National Grid Electricity Transmission – Sea Link – EN020026

Comments on Applicant's Change Request

Benhall Bridge – Traffic Diversion Route

Sea Link

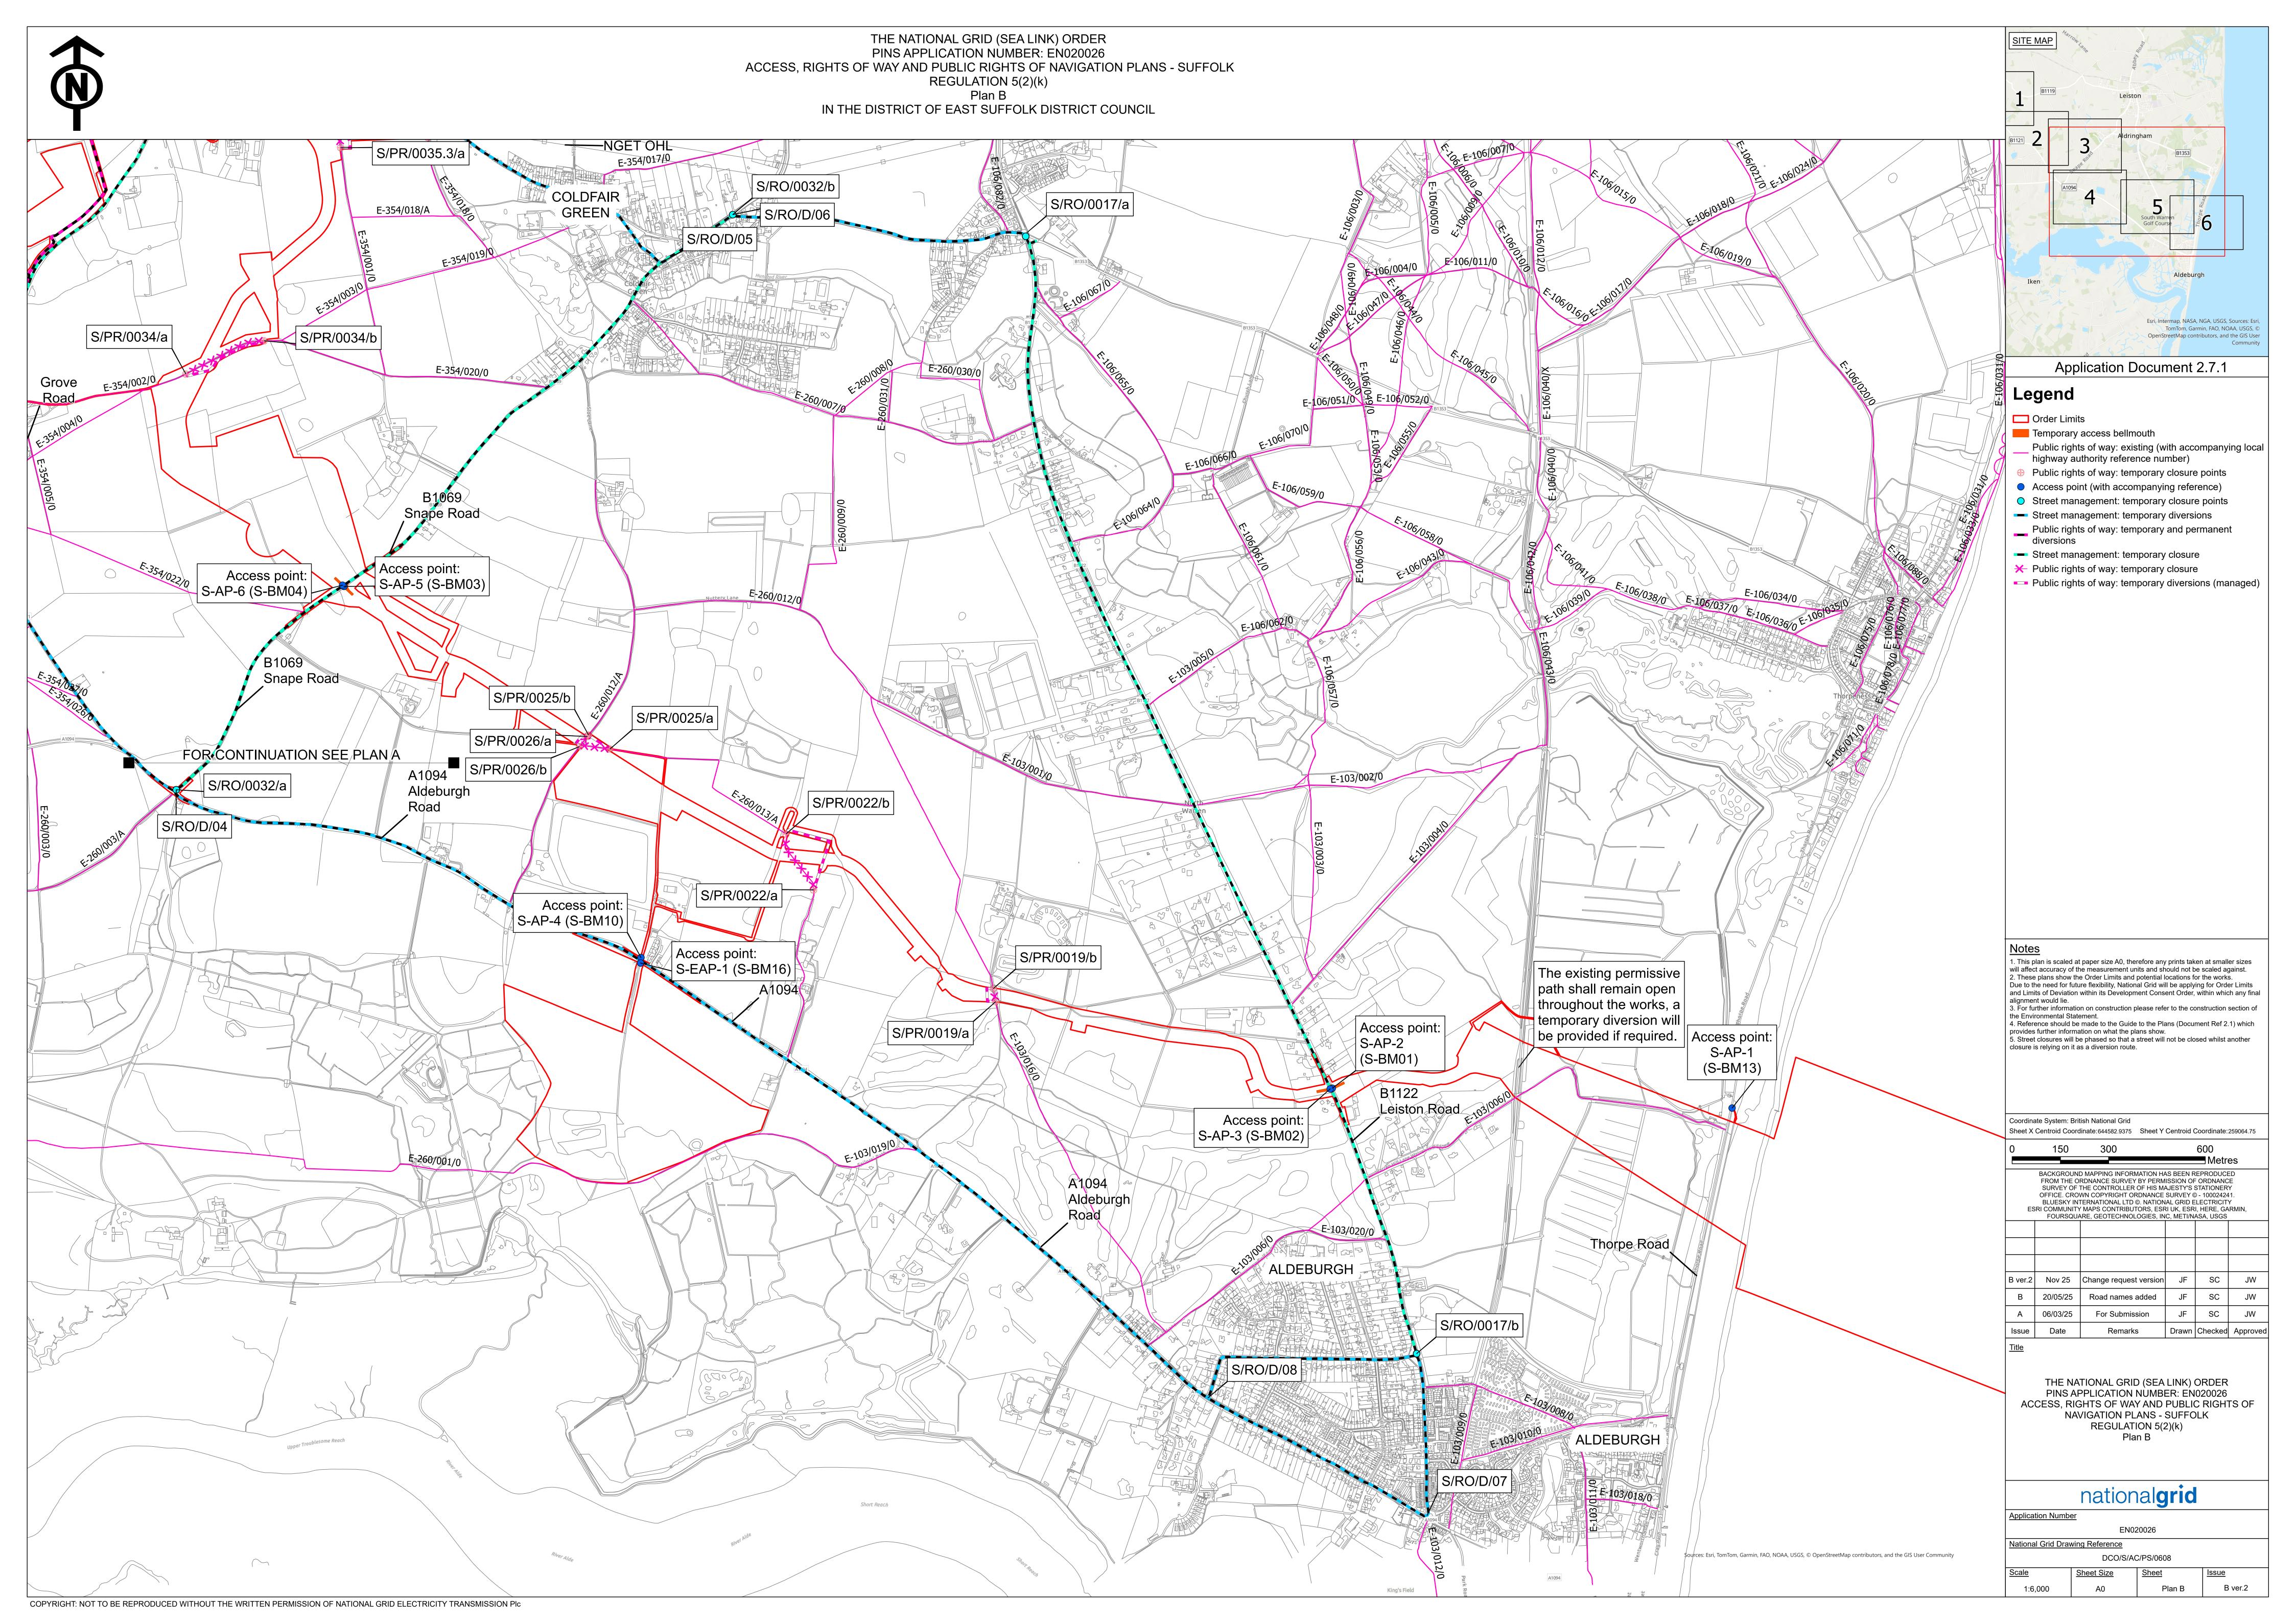
Ensuring HGVs do not follow the diversion route as illustrated on Document 2.7: Access, Rights of Way and Public Rights of Navigation Plans, Version: B Version 2 Change Request, November 2025 but instead use the designated HGV routes identified by Suffolk County Council Highways.
